DECISION DELEGATED TO HEAD OF PLANNING

Application No: H09-0210-25 **Applicant:** Mr N Marshall
Proposal: Conversion of 2 existing flats to create 4 flats
Location: Bank House 1 Albert Street Holbeach
Terminal Date: 1st May 2025

PROPOSED FLOOR PLANS
scale 1:100

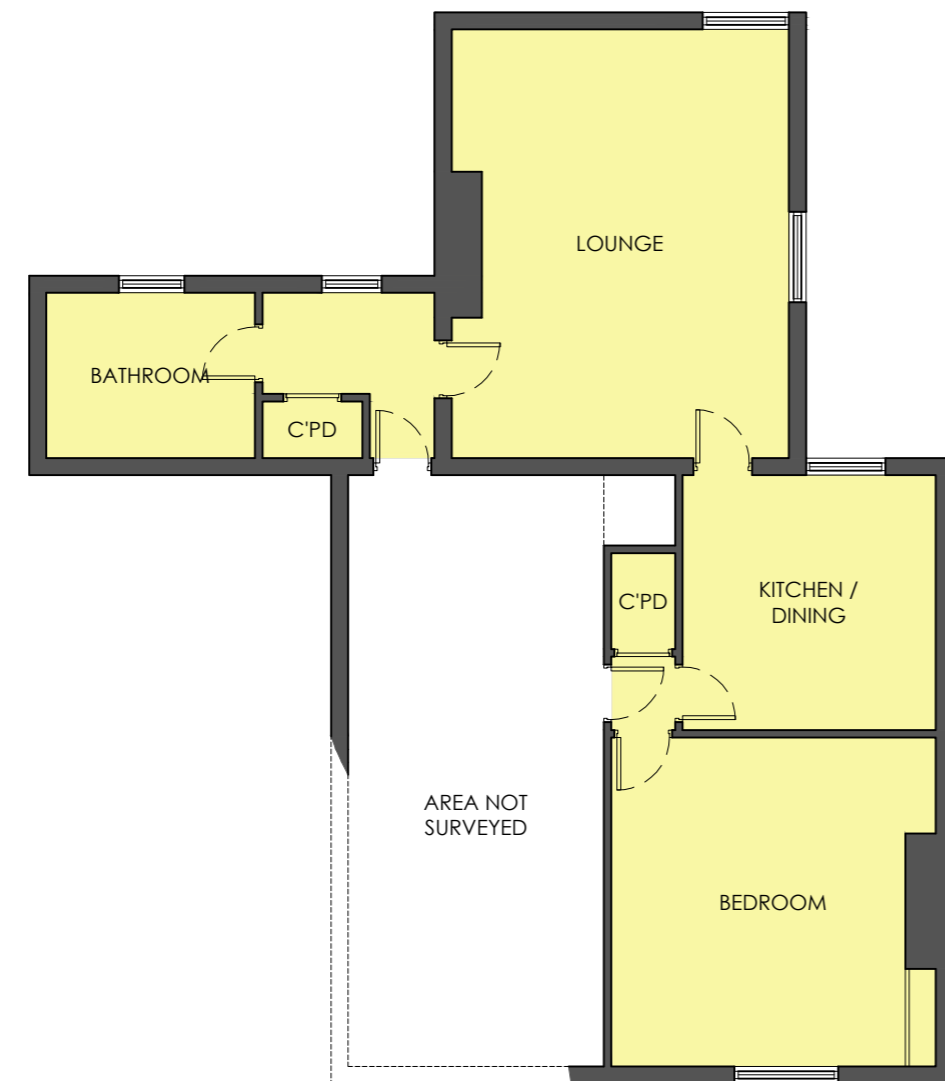
This is a full application for the sub-division of two existing flats to create four. Currently, there is a single, one-bedroom flat per floor, measuring 77sqm on the ground floor, and 70sqm on the first floor.

PROPOSED FLOOR PLANS
scale 1:100

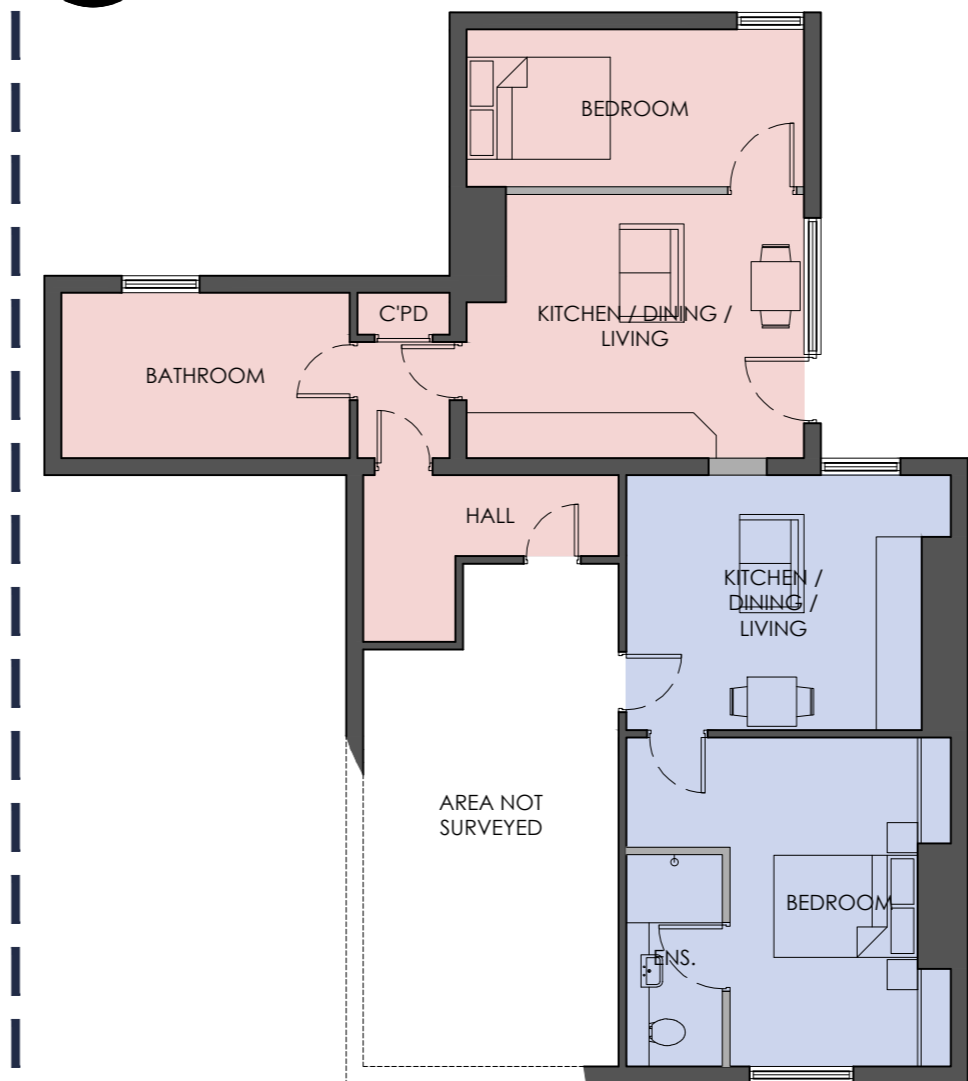
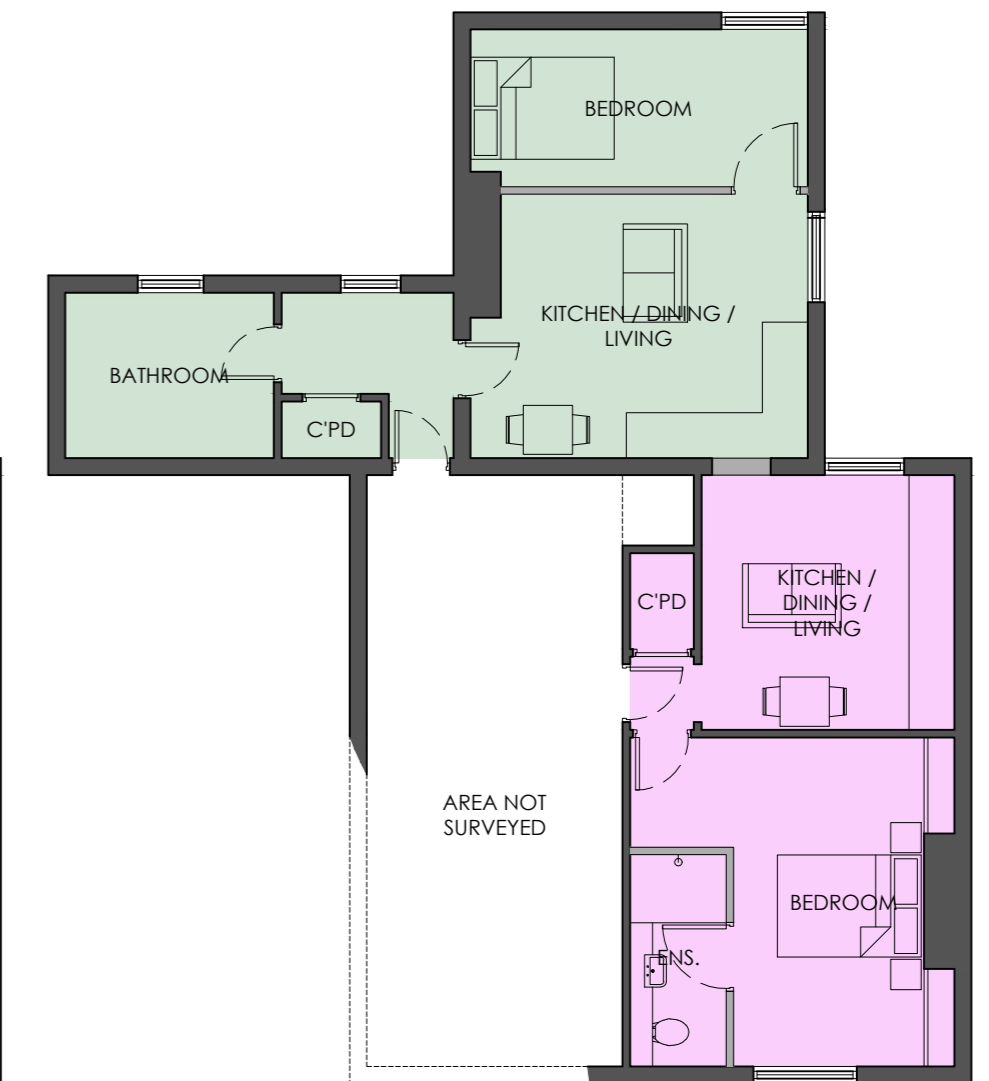
It is proposed that two, single-bedroom flats per floor are created. On the ground floor these would measure 33.5sqm and 42.7sqm. On the first floor they would measure 32.5sqm and 37sqm. Internal walls are proposed to facilitate the change, in addition to the minor internal demolition of an internal entrance way.

7.The Nationally Described Space Standards (NDSS), which are explicitly referred to later in Policy 21, require a minimum internal floor area of 37sqm for a one-bedroom flat with a shower room or 39sqm for a bathroom. The NDSS are designed to be minimum level to achieve a decent standard of living space, and ideally should be exceeded if possible. Two of the four dwellings are below the NDSS, and a third is just on the cusp. No communal amenity space is indicated on the plans. As the proposal falls under the NDSS, it is considered that the proposal fails to provide adequate amenity space, and therefore fails to conform to the provisions of Policy 21.

As outlined above, two of the dwellings fail to reach the standards required under the NDSS. No shared amenity space has been provided here. As such, the proposal is considered to fail to provide an adequate level of amenity for its occupants.

Two of the four flats fail to provide adequate internal amenity space, falling below the levels required under the NDSS. Policy 21 is explicit that proposals for the sub-division of dwellings should provide an adequate standard of residential accommodation and that the NDSS should be applied to ensure this. Accordingly, the development fails to conform to the requirements of Policy 21. No shared amenity, either internally or externally, has been provided to remedy this shortfall.
